# CITY OF ALBUQUERQUE

**Re: The Team Office Building Grading and Drainage Plan**  
**Conceptual, Engineer's Stamp Date 05-02-12 (C-12/D026)**

No FIRM
No pond calc's
Not NAVD88
Basin 102 outflow?

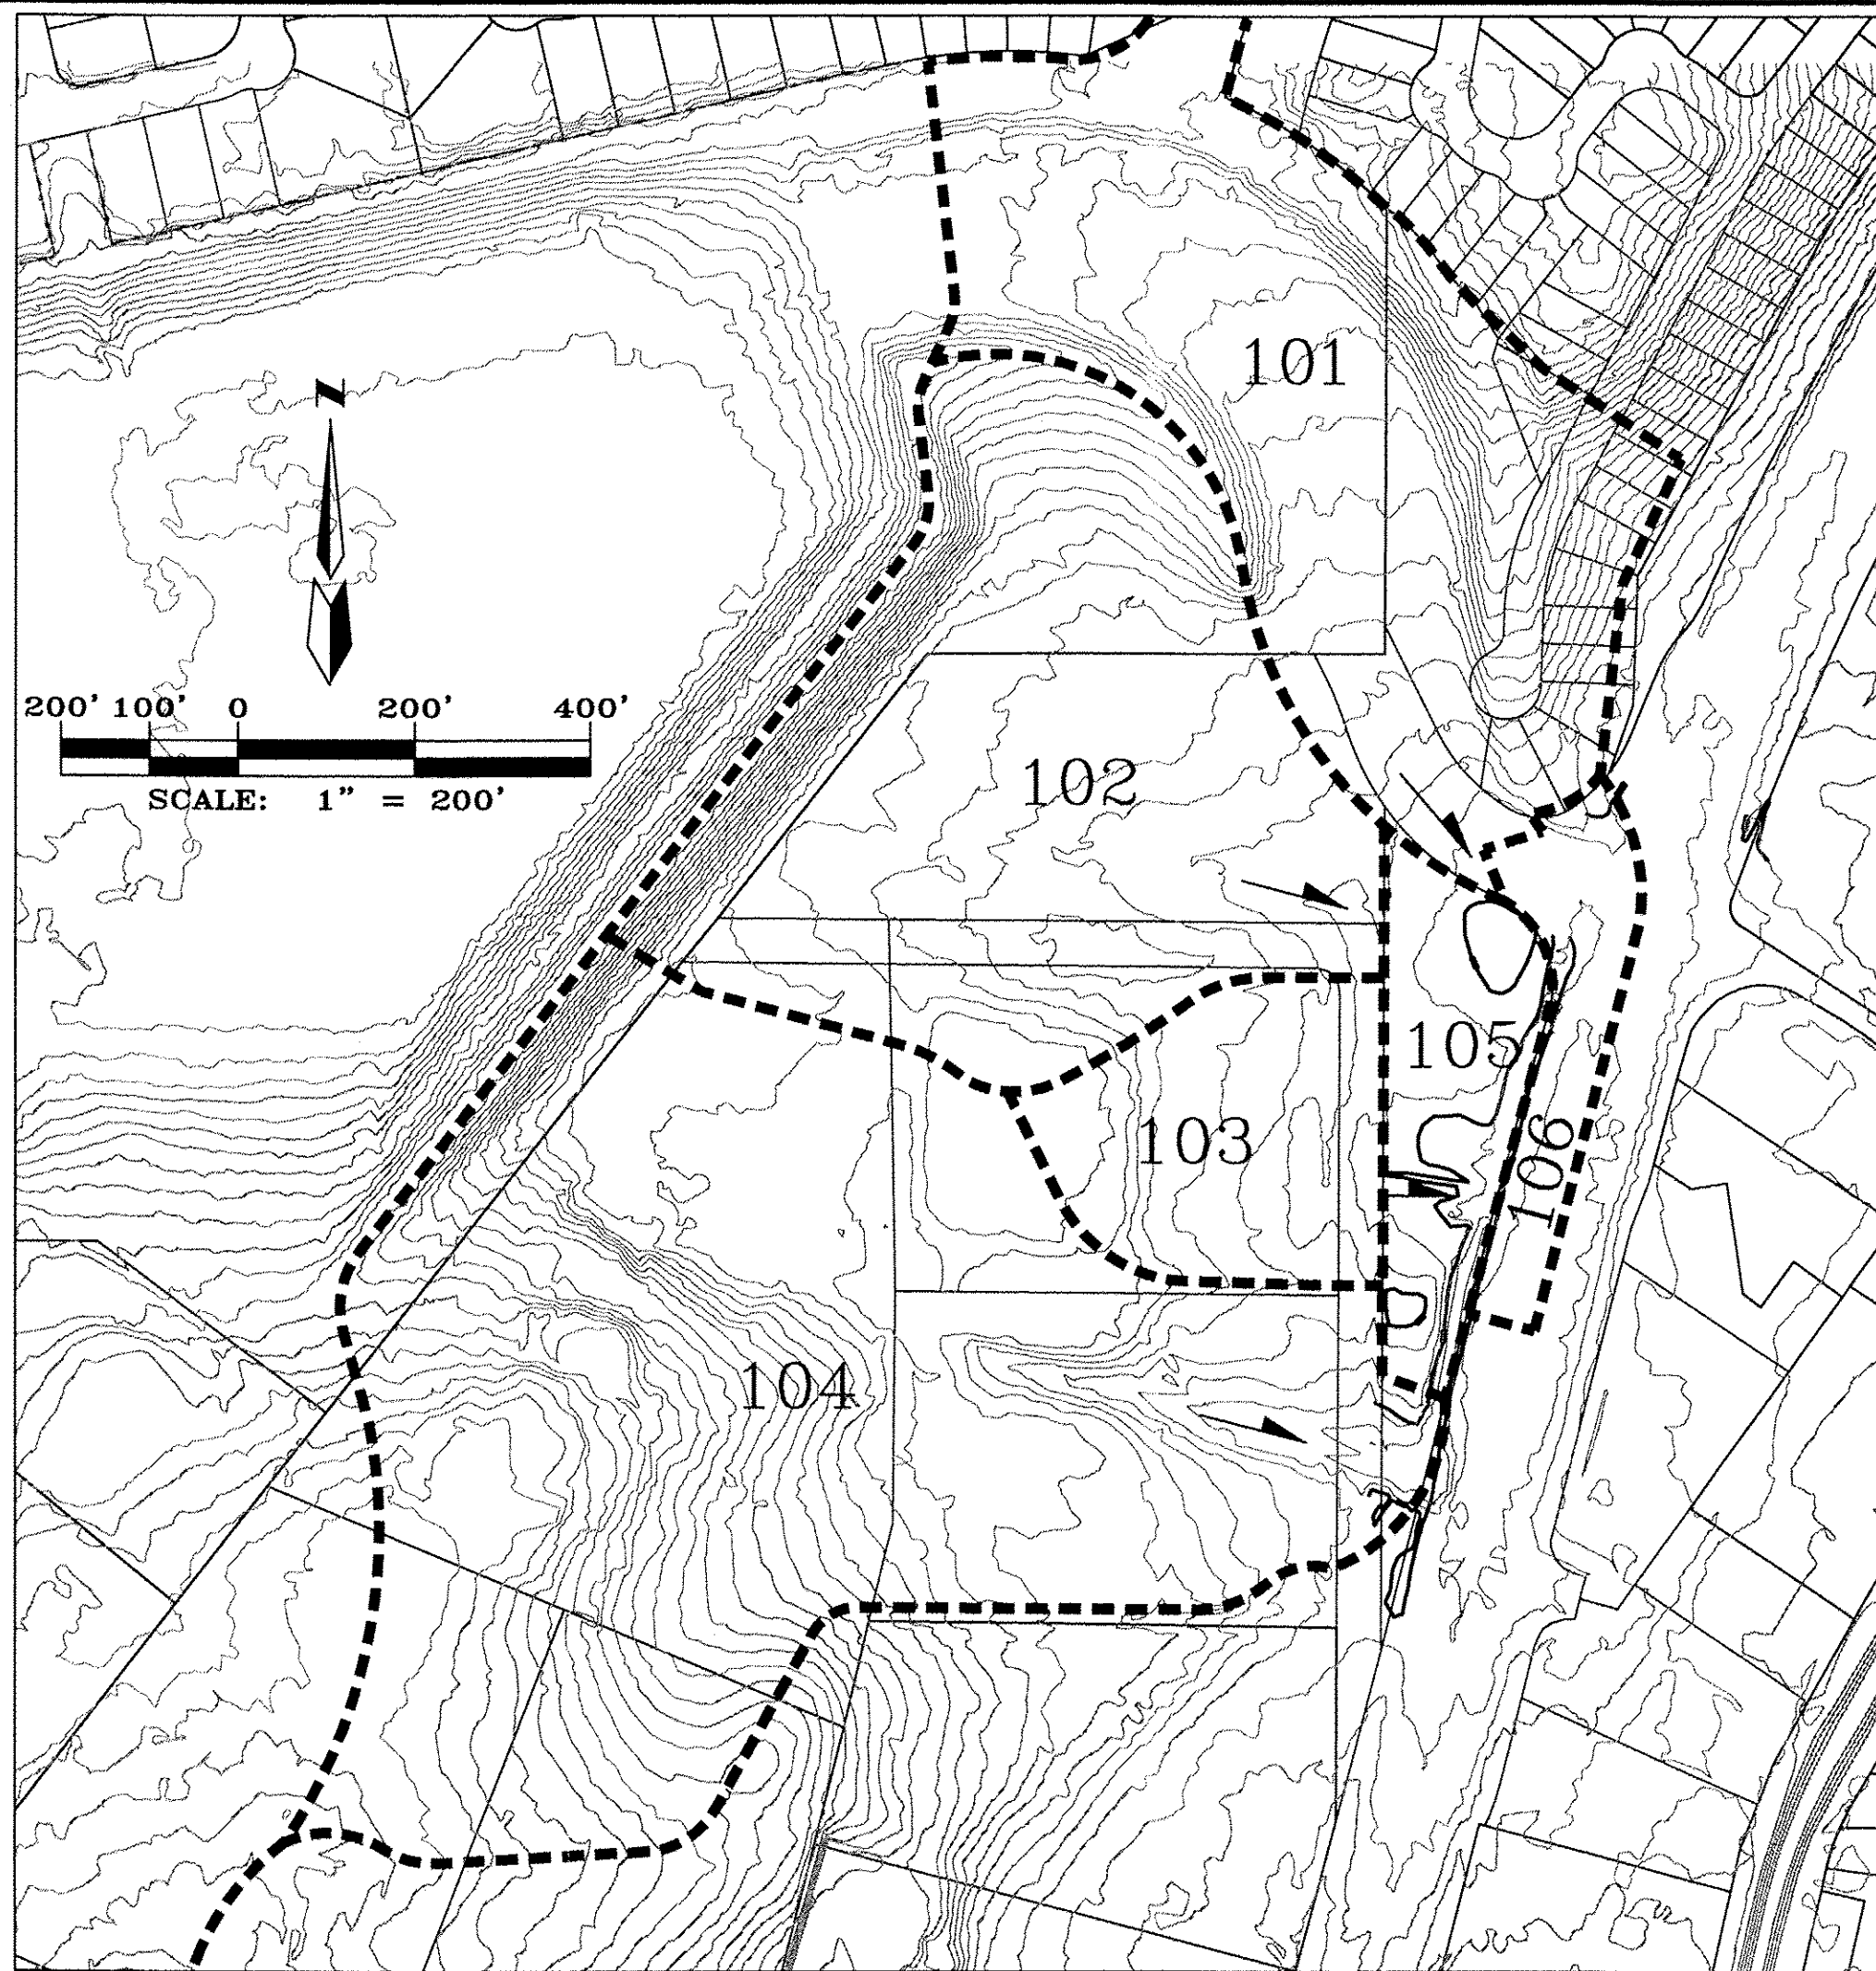
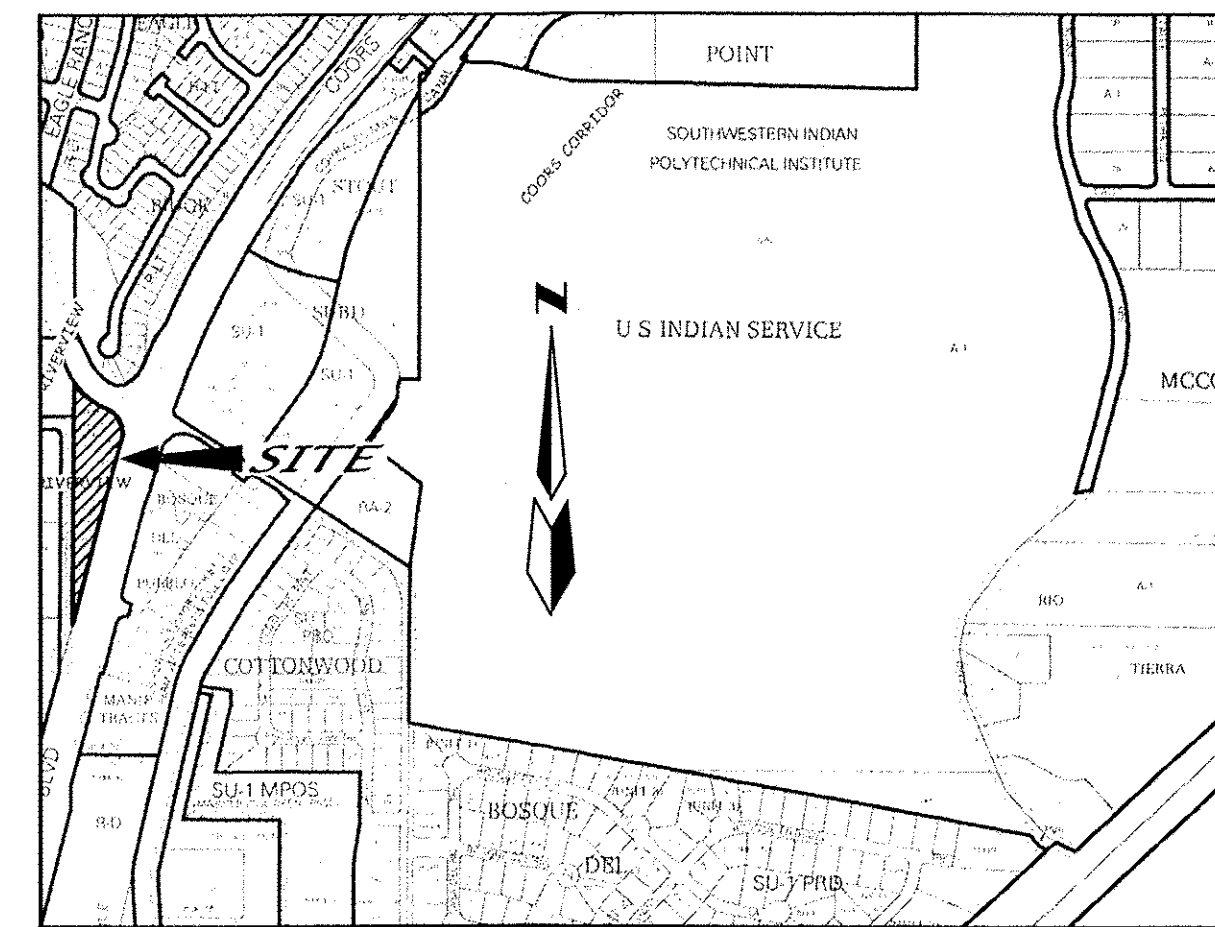
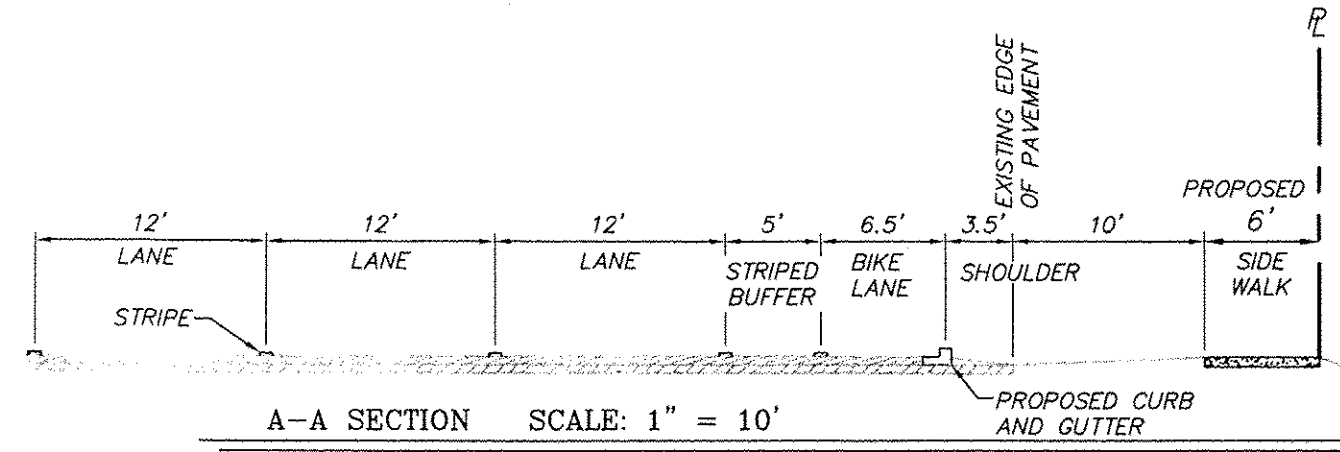
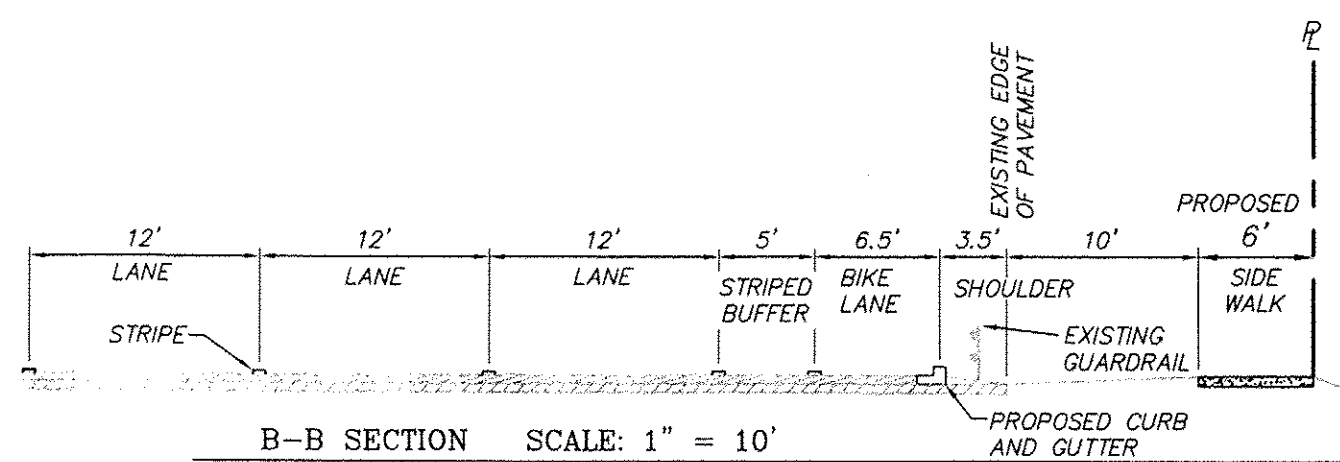
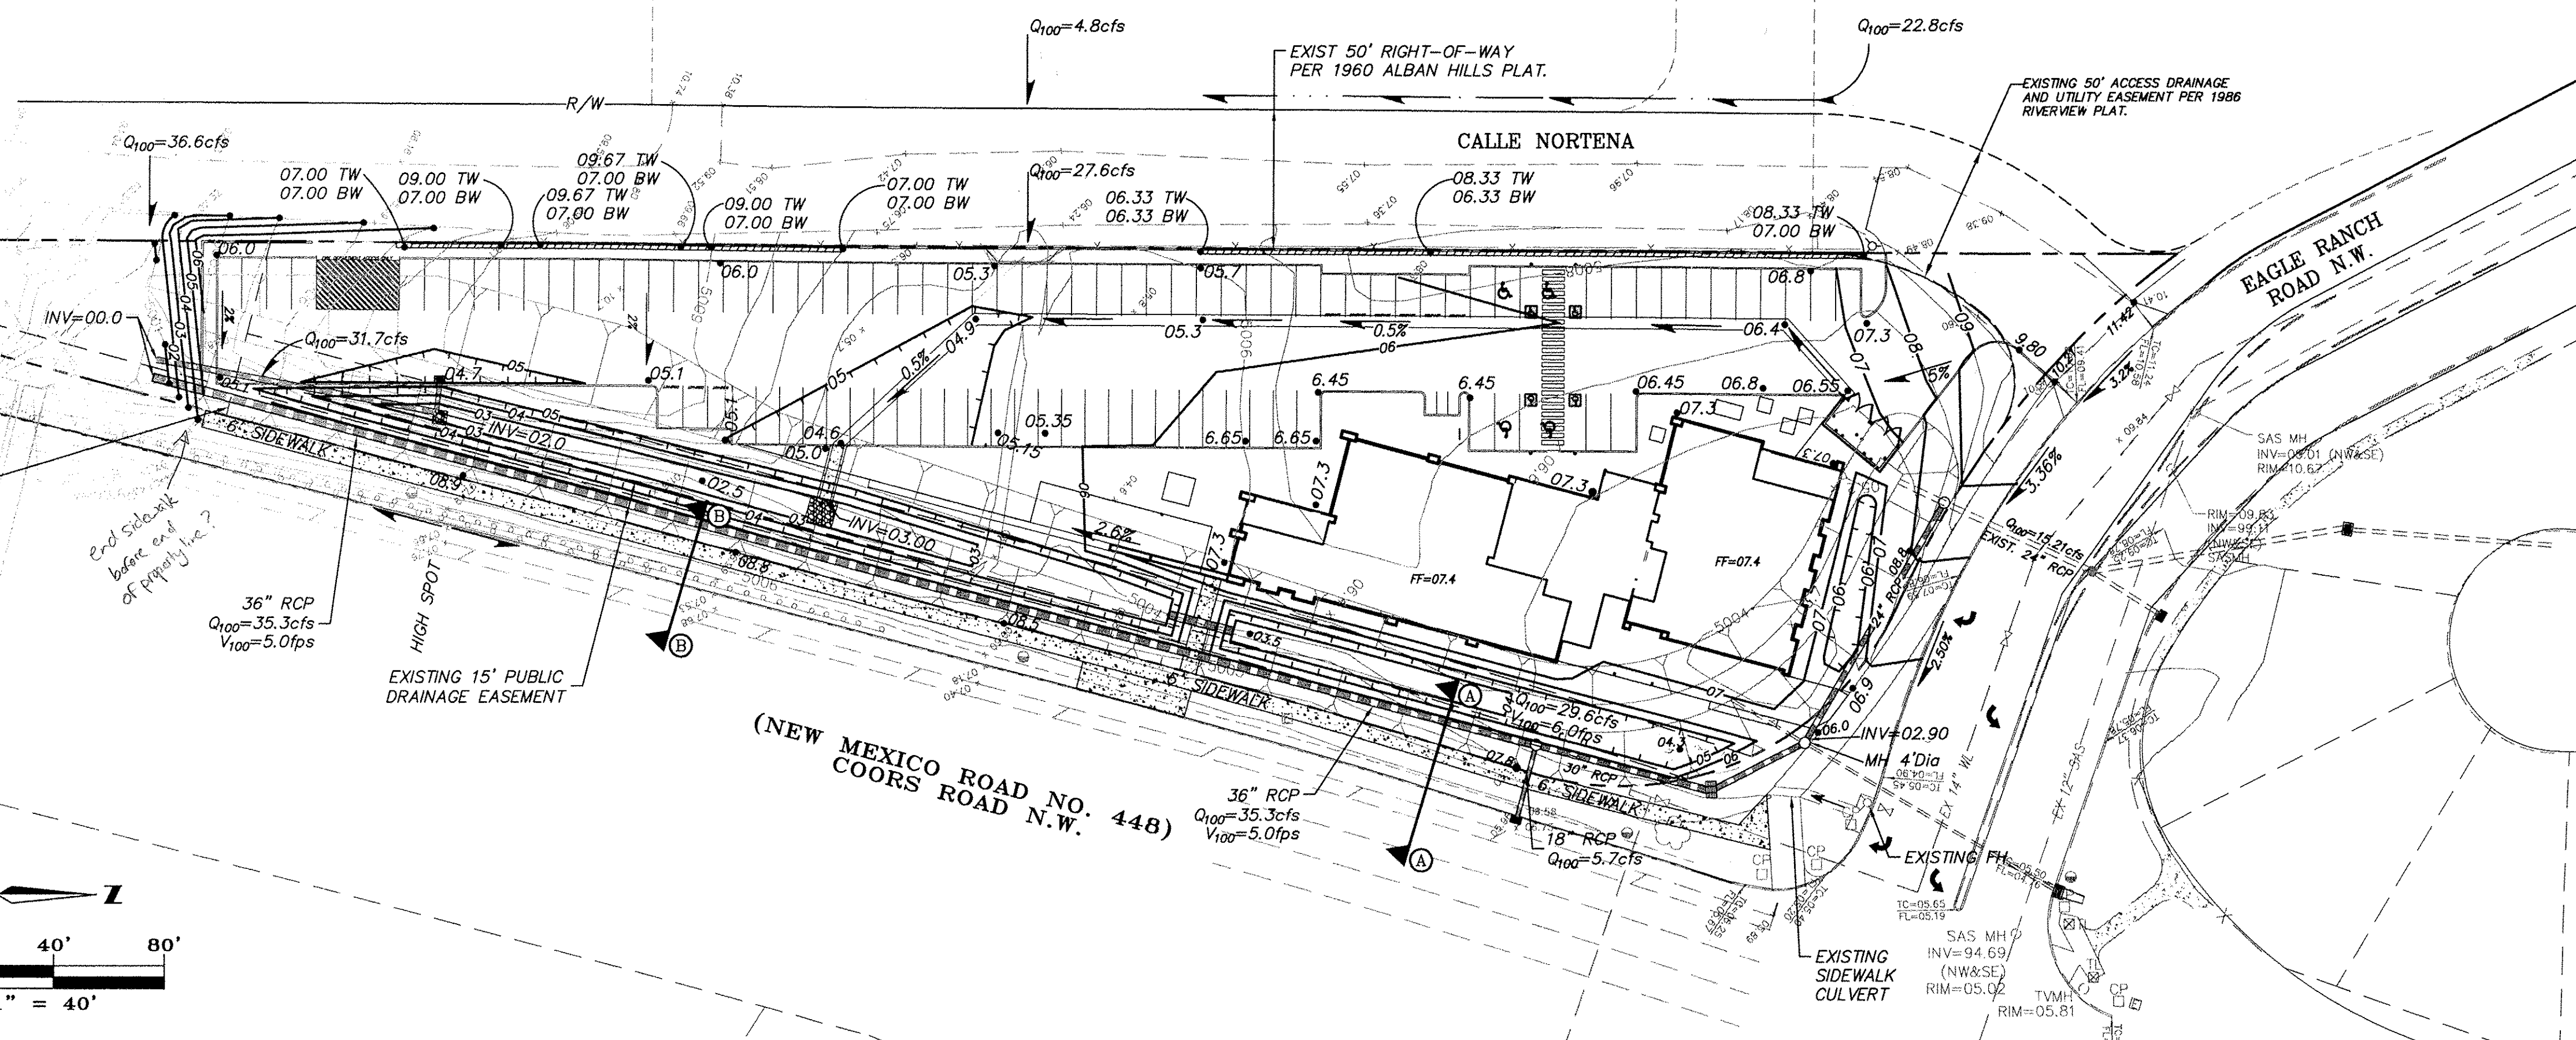
Based upon the information provided in your submittal dated 05-03-12, the above referenced plan cannot be approved conceptually until approval is obtained from the State Highway Department for the improvements within their right-of-way.

- The right-of-way on the western edge of the property is county owned and any required roadway improvements will need to be addressed prior to construction.
- The outflow from Basin 102 of 22.8 cfs does not match the figure in the North Coors DMP of 8 cfs for Basin 13.1W, please clarify this value.
- How does the proposed detention pond adequately mitigate both accepting the offsite flows from Basins 103 and 104 as well as any increases in onsite runoff? Please provide pond calculations.
- How will the outfall on the southern edge of the property be protected from offsite flows?
- Please provide sidewalk culvert details for the central sidewalk portion of the project. Will it be covered?
- All benchmarks and elevations should be referenced to NAVD 88 standards.
